Department of Transportation

February 7, 2022

RE: Western Museum of Mining & Industry (WMMI)
Variance of Use | VA204

I am in receipt of a referral request for comments for Western Museum of Mining & Industry (WMMI). The WMMI submittal involves a Site Development Plan Variance of Use requesting consideration to allow WMMI to hold business center activities on the referenced site. The plan submittal indicates areas commonly used for activities, parking, vendors, etc. Depending on the size and type of event, the general patterns may be adjusted. The property has the tax schedule No. 6207200017, consists of 28.39 acres and is zoned RR-5 (Residential Rural). It is located on the east side of I-25 and south of Northgate Boulevard, in the NE ¼ of the NE ¼ of Sec 7, T 12S, R 66W, of the 6th PM in El Paso County, Colorado. After review of all documentation, we have the following comments:

### WMMI Entry Traffic Flow and Control Plan

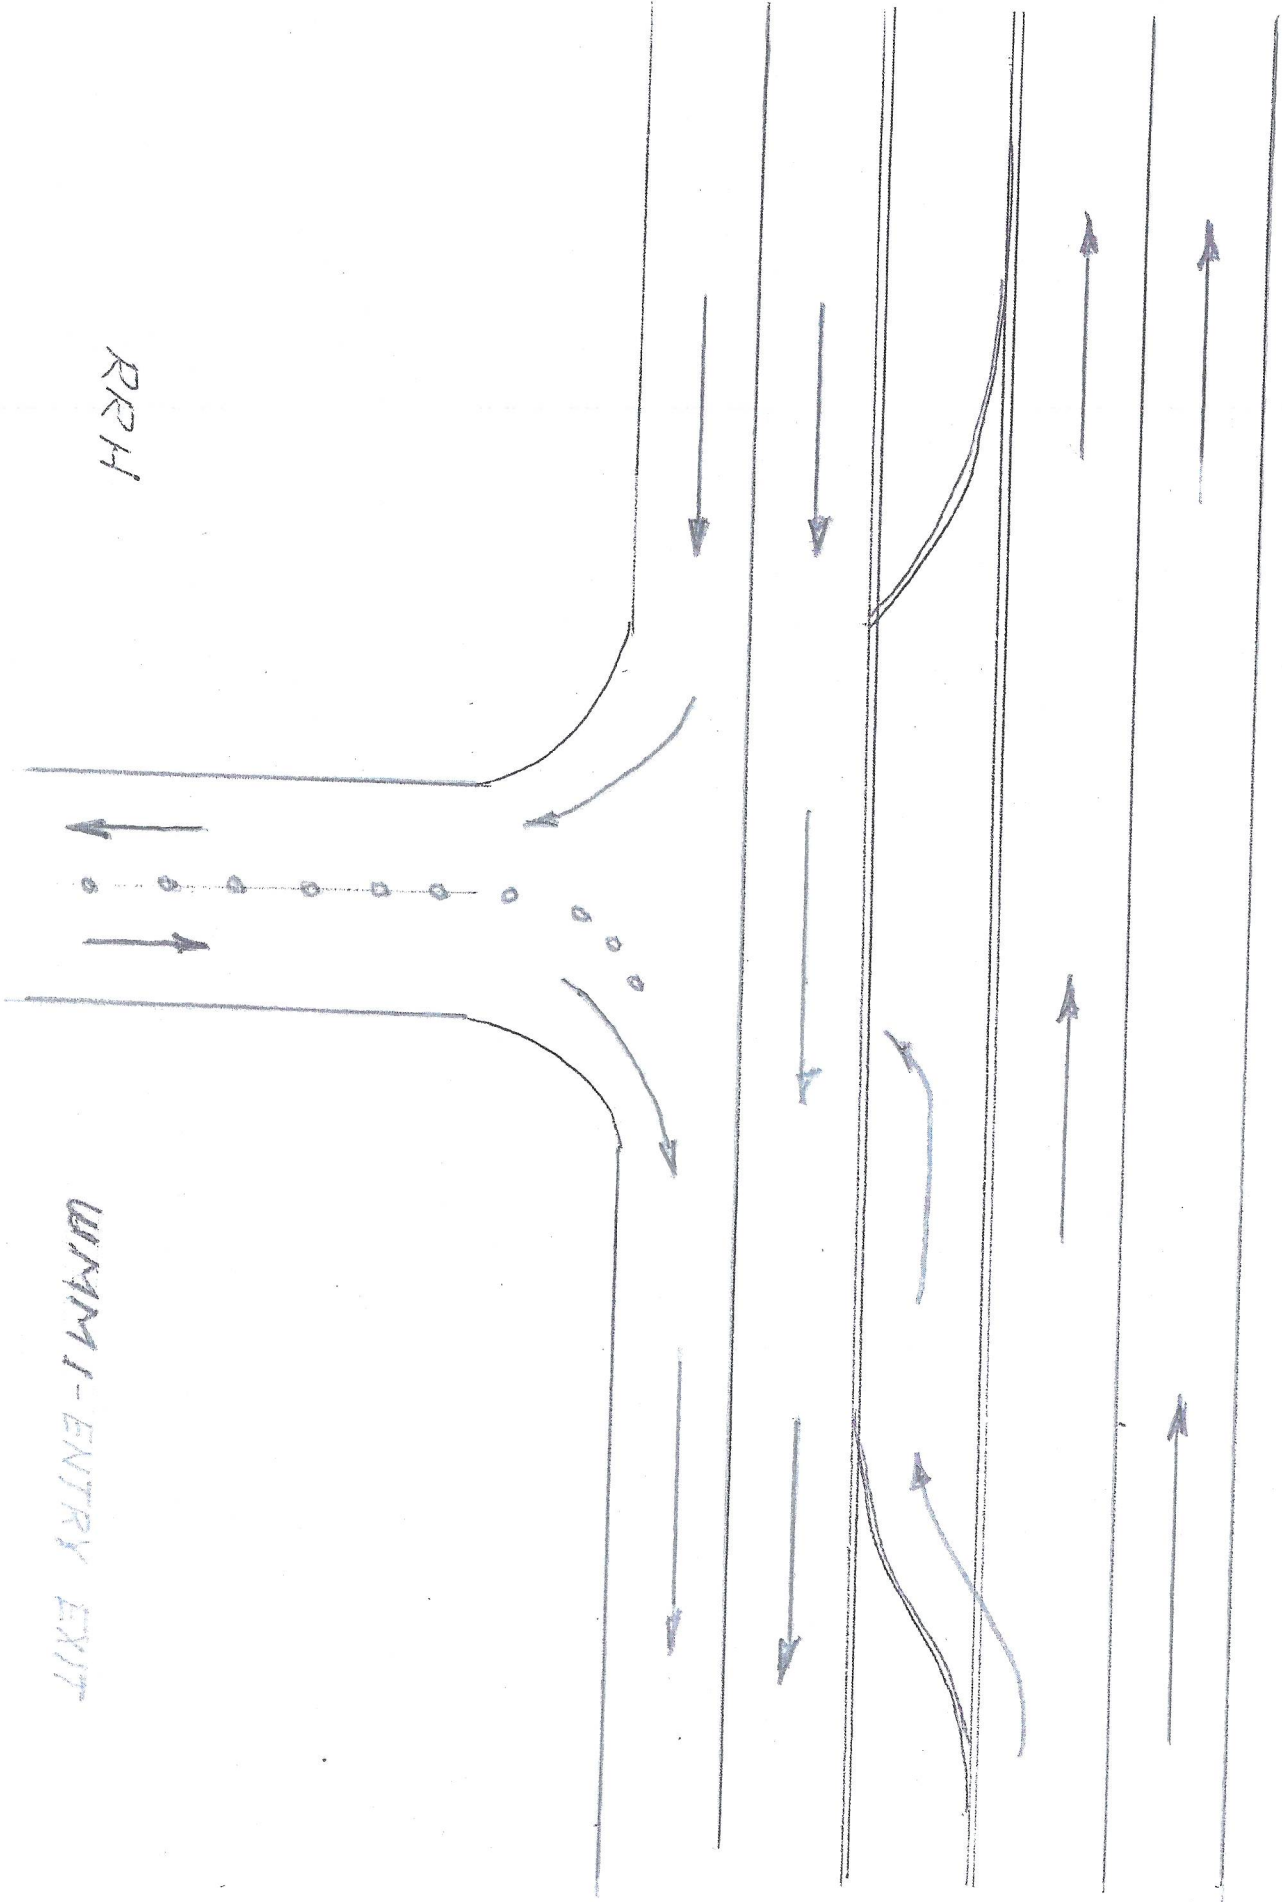
- CDOT accepts the analysis in the TIS mentioned above.
- Future traffic control concerns to be noted and recorded as part of the permitting process for the City of CS/El Paso County permits should require the following. During large events (1250+ visitors or 401+ cars), the westbound left turn movement shall be restricted with use of temporary traffic control. For all events with 100+ vehicles, the exit movement shall be restricted to right out with the use of temporary traffic control.

- The Western Museum of Mining & Industry will be required for every special event to get a Colorado State Patrol Special Events Permit and make sure the traffic control concerns above are being addressed as required.
